**Able Humber Ports Ltd
Marine Energy Park
Proposal to build a quay and associated development on
the south bank of the River Humber**

Planning Inspectorate Reference: TR030001

**Comments on other parties' responses to
The Examining Authority's 1st Written Questions**

**On behalf of
The Environment Agency
Unique Reference Number: Ref No. removed**

Figure 28-1 Cherry Cobb Sands site layout

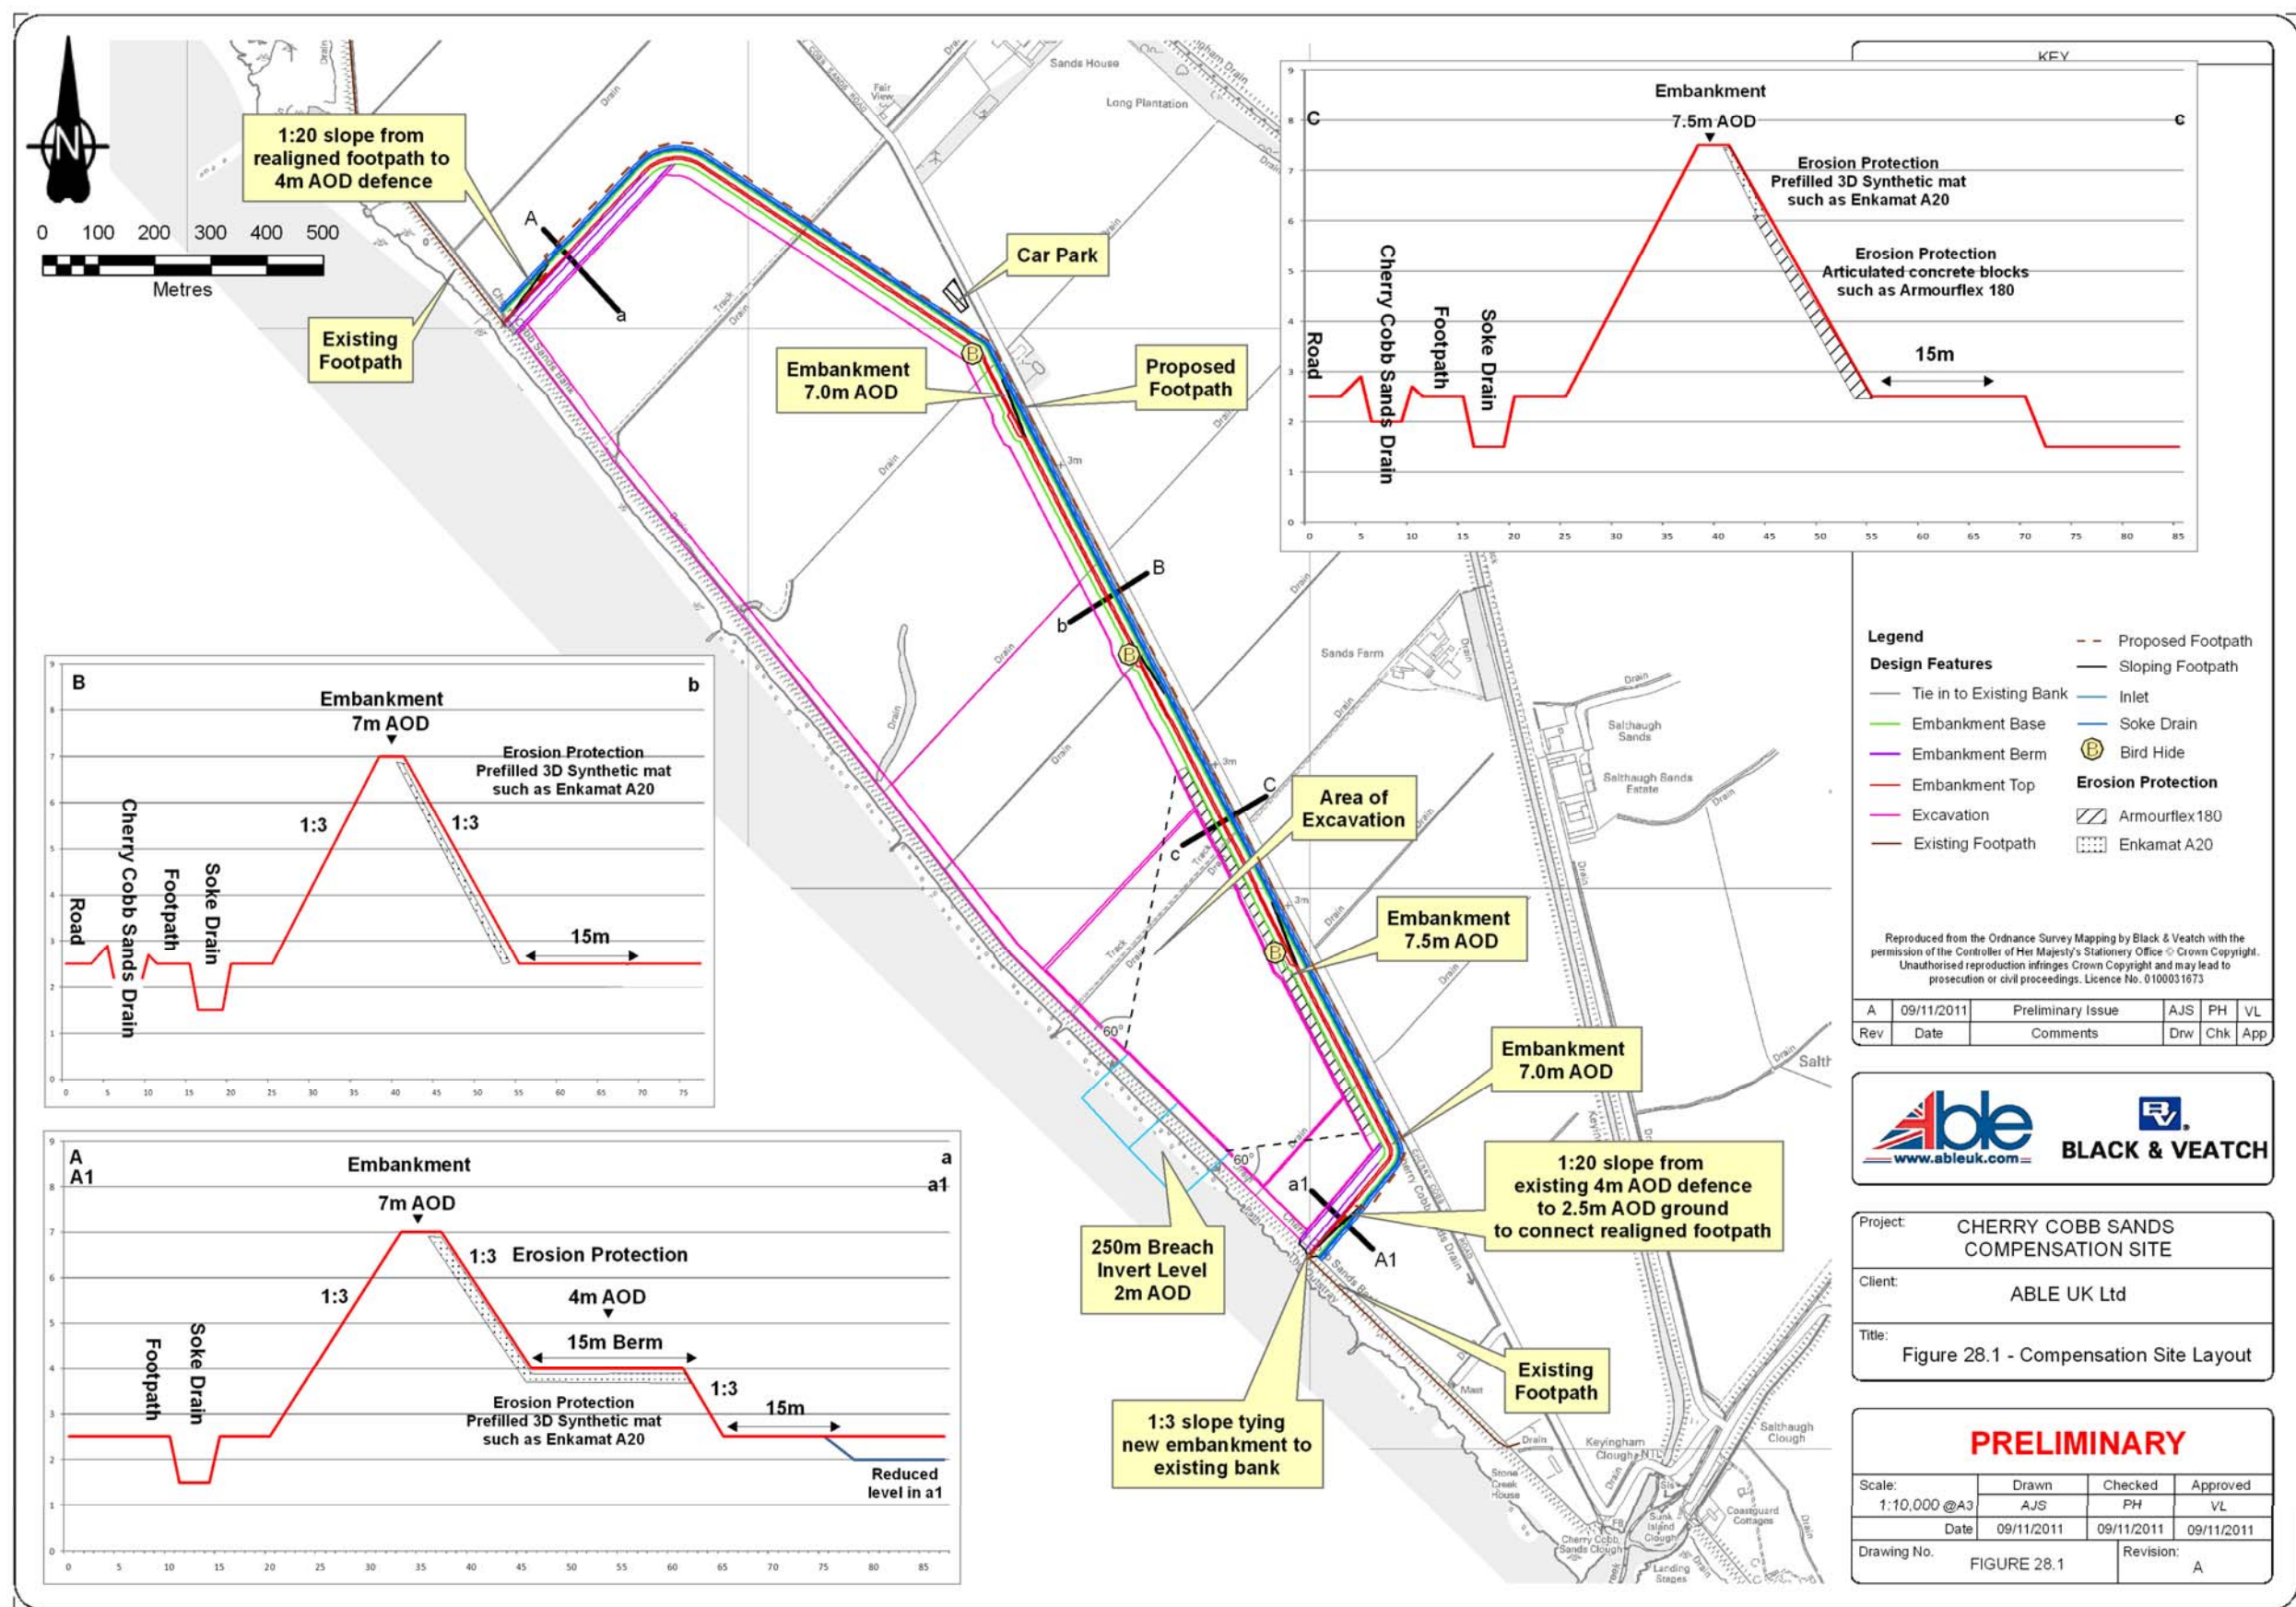
The EA has not been able to undertake a comprehensive review of EX28.1 at this point in time, but we have been advising the applicant on potential alternatives to consider in delivering the compensation site. The EA was not, however, invited to the most recent compensation site design workshop (held on 4th July 2012, attended by the applicant, their consultants and Natural England) and are unable to comment on those discussions. Once we have fully reviewed report EX 28.1 we will submit our formal response, but we anticipate that this report will need to be updated in the light of the potential use of a regulated tidal exchange (RTE) scheme at the Cherry Cobb Sands site and we understand modelling work on this is currently being undertaken.
